Planning Ref: ACP-324015-25

Re: Notification under the Planning and Development Act, 2000, as amended

Substitute Consent Application by Milford Quarries Limited for further development consisting of further quarry extraction over an area of c. 16.17 ha to include the pre-existing quarry extraction area and additional agricultural lands in the western and southwestern portion of the site. The projected lifespan of the quarry is c. 20 years. The proposed development will involve blasting, extraction and processing of rock using mobile primary crushing / screening and associated plant on the proposed quarry floor. The proposed quarry void will be extracted over 4 no. phases (phase 1 will involve levelling of existing quarry floor; phase 2 will expand existing extraction area to the west with a single bench depth of c. 20 m; phases 3 and 4 will expand the extraction area to the south west to a depth of 2 no. benches of c. 10m each) The resulting quarry floor depth will be c. 300m AOD with a proposed rate of extraction of c. 200K tonnes per annum over the projected lifetime of the quarry. The proposed development will include for construction of earthen screening berms, expanded soil

D109
SETTLEMENT POND DETAIL
SCHEMATIC

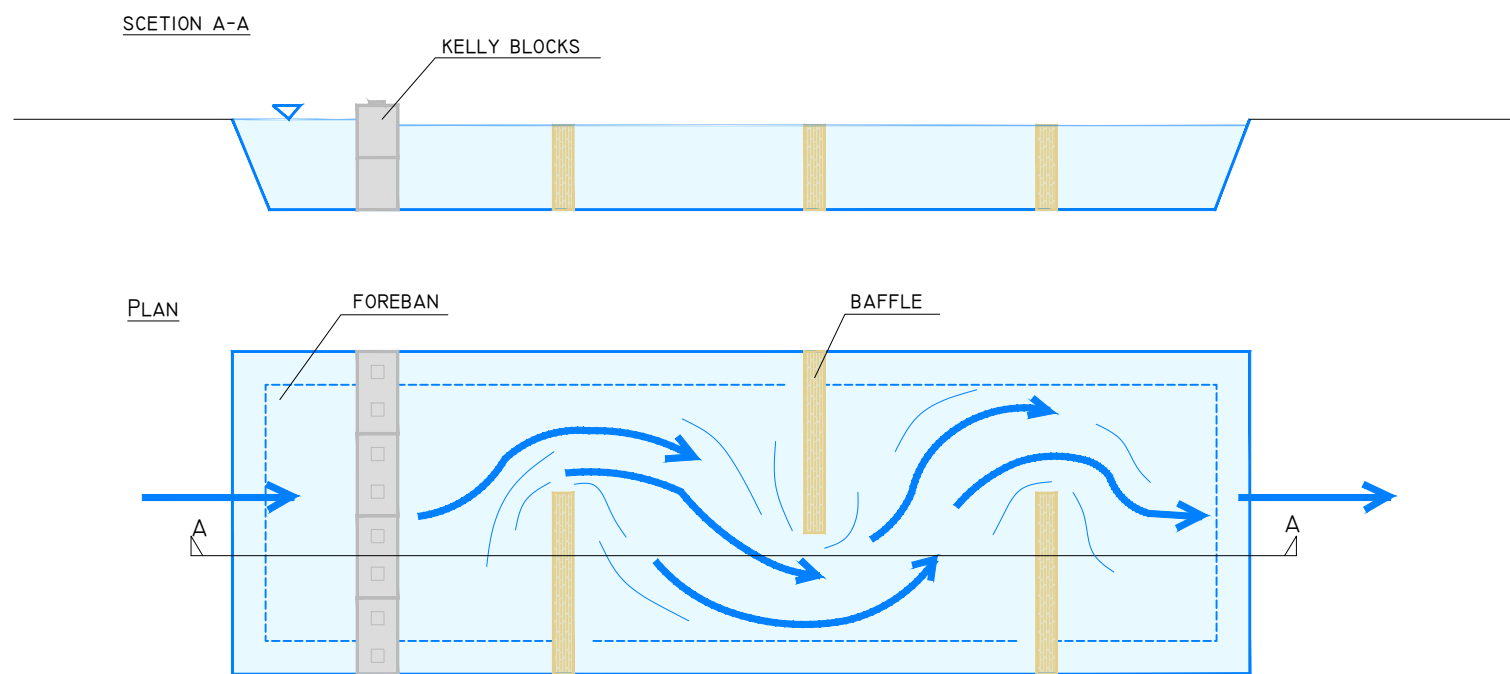
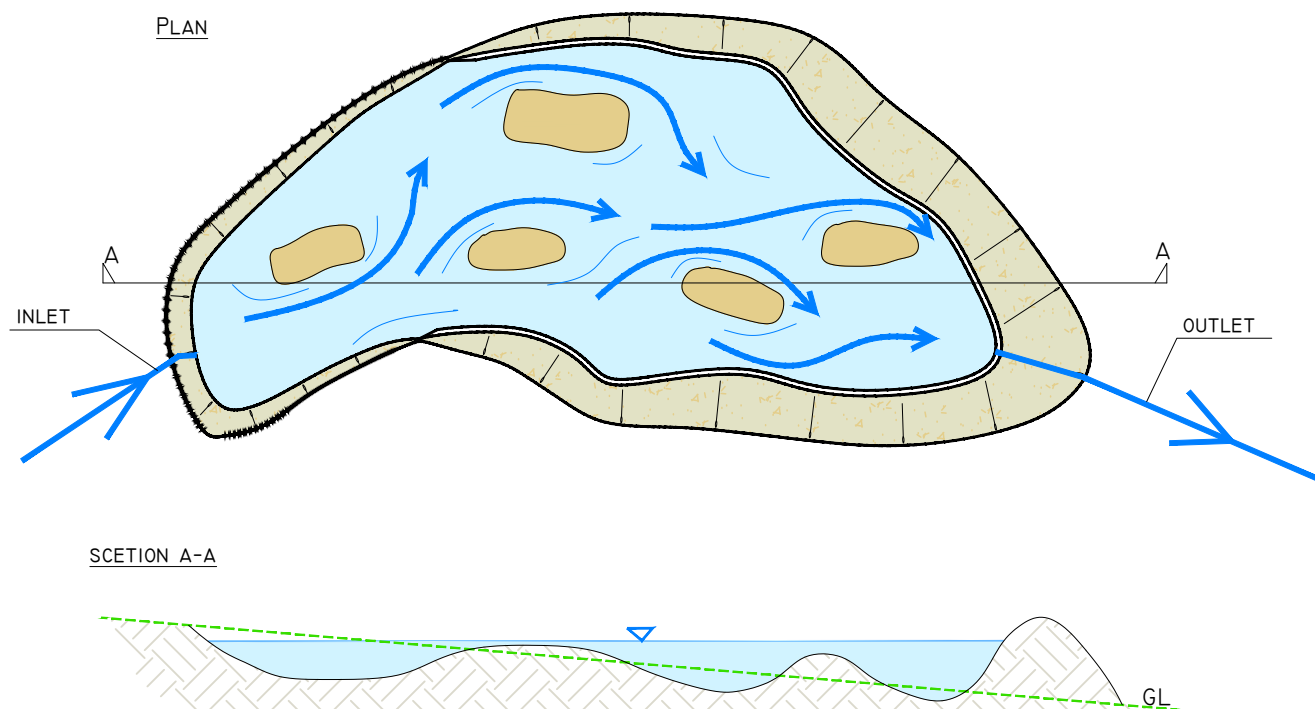
The NIS relies heavily on the conclusion that water quality impacts can be avoided through the operation of settlement ponds, hydrocarbon interceptors, attenuation measures, operational management procedures and adherence to best practice mitigation. While such measures may be appropriate, insufficient detail has been provided regarding the design capacity, performance standards, maintenance requirements and long-term effectiveness of these systems over the proposed 20-year operational life of the quarry. In the absence of this information, it is difficult to determine whether the proposed mitigation is capable of ensuring the protection of downstream qualifying interests under all operational and extreme weather conditions.

The submitted information confirms the presence of Smooth Newt and Common Frog within quarry ponds. The proposed mitigation includes pond creation, translocation and monitoring measures, indicating that impacts on existing breeding habitat are anticipated.

Further information should be provided regarding:

- the timing of pond loss
- timing of replacement habitat creation
- receptor site suitability
- habitat management arrangements
- long-term monitoring commitments and success criteria
